The Parish Councils of Assington, Bures St Mary, Leavenheath, Little Cornard, Polstead & Stoke by Nayland

Written comments following Bramford-Twinstead (EN020002) Issue Specific Hearing 4 & Further combined response to Examining Authority's Submission Deadline 4

2. Relocation of the DVEast CSEC in Section D/E to Layham Quarry

ELEVATION - A
 SCALE 1:150

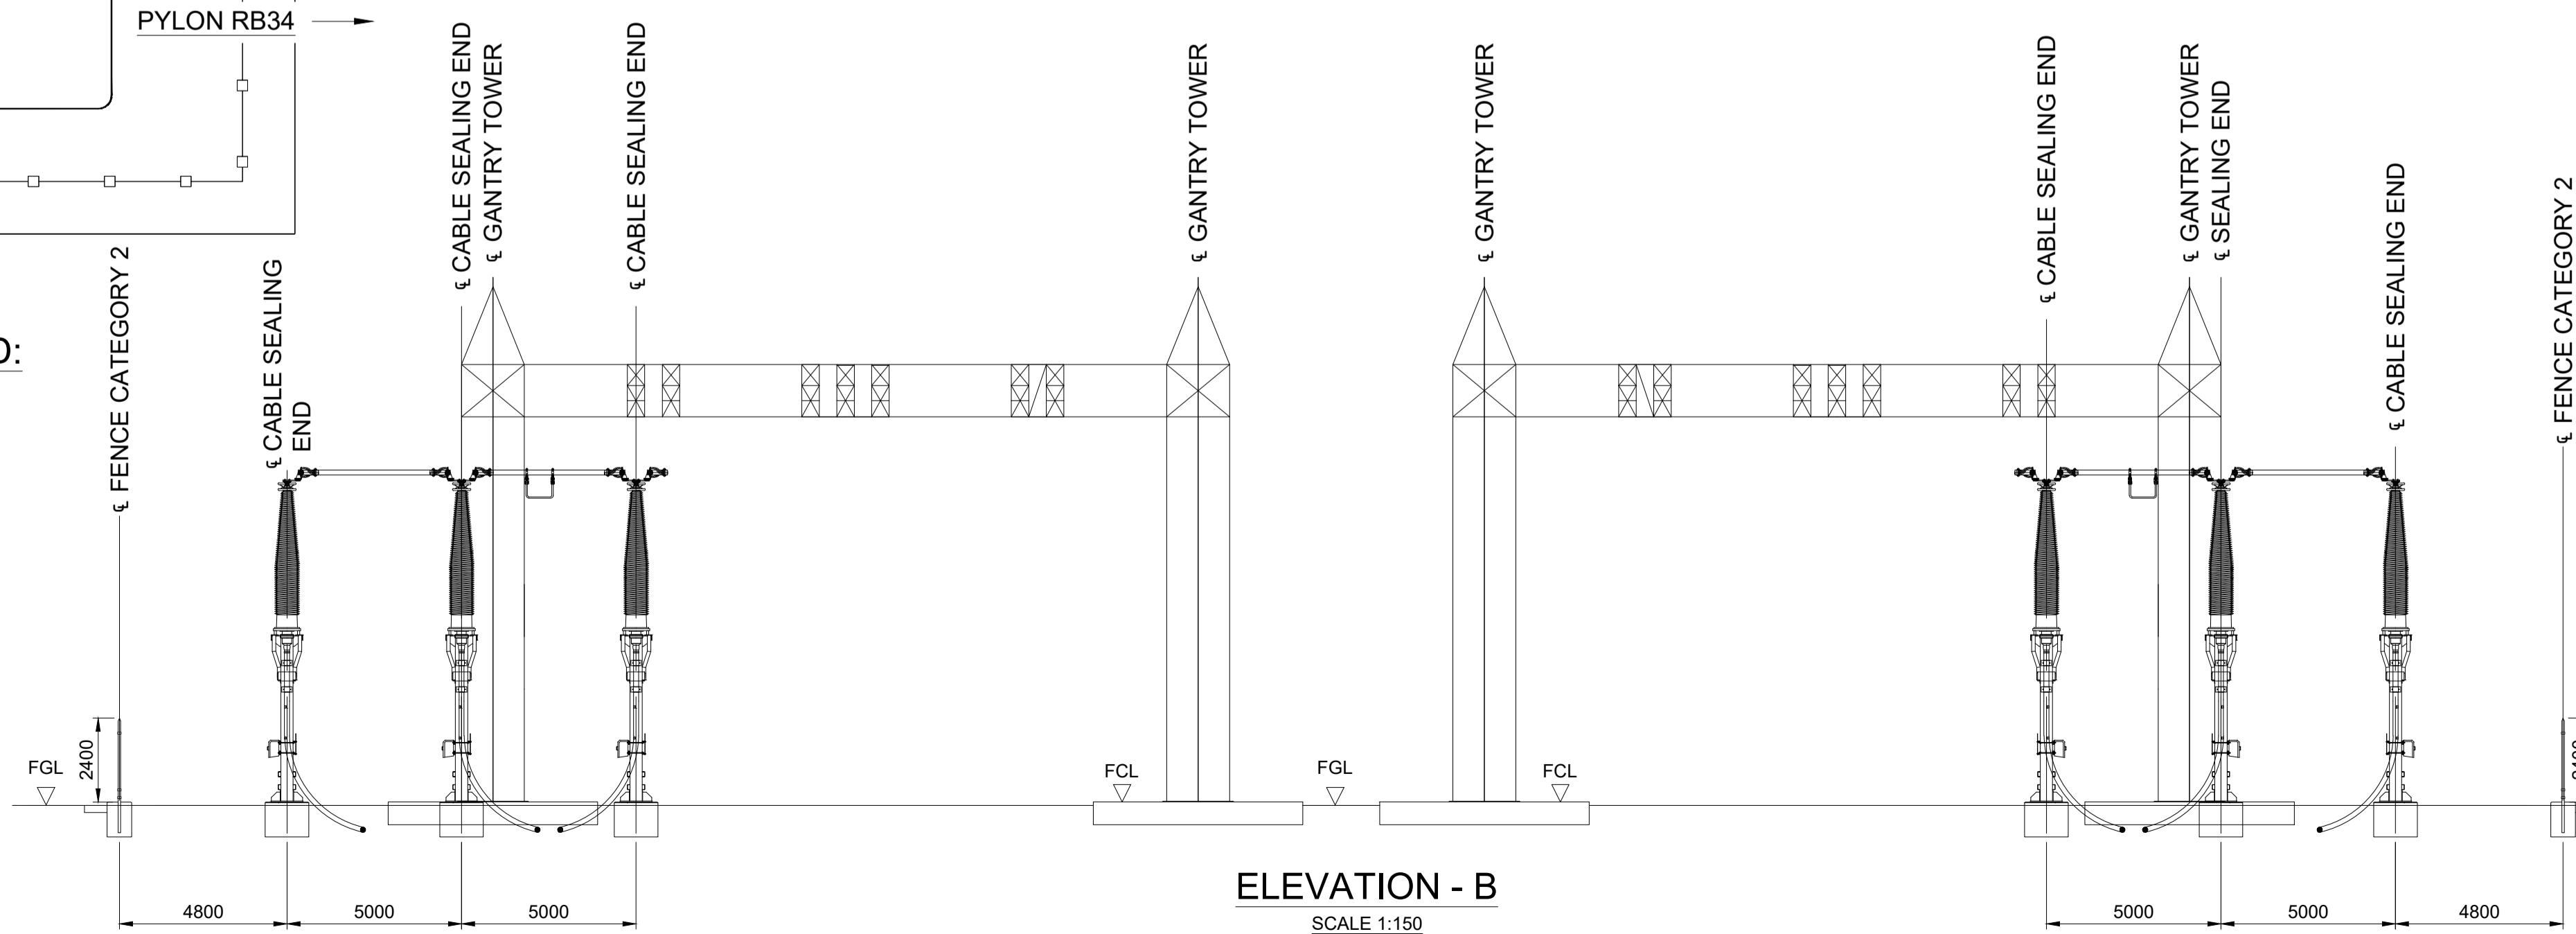
- 2.3 We wish to reinforce the industrial scale and nature of infrastructure required within a CSEC, essentially massive civil engineering structures comprising steelwork lattice gantries of near 15metres height distributed over a 50metre width (APP-023, Document 2.11.5). Such structures would be impossible to screen using embedded planting beneath the descending overhead power lines or above buried cables, and as such are destined to remain an essentially alien intrusion into the countryside for as long as the infrastructure is required.

- 2.14 **It is our proposition that the 70 x 45metre CSEC compound can readily be transposed to a site immediately adjacent to the western boundary of the quarry** and coincident with the line of Work No 2 and the site of new pylon RB32. This is a distance of just over 800metres from Millfield Woods site and results in the elimination of three new pylons. As far as we are aware, there are no civil engineering constraints that would impede construction or operation at this location, which appears to be in an already worked-out section of the quarry.
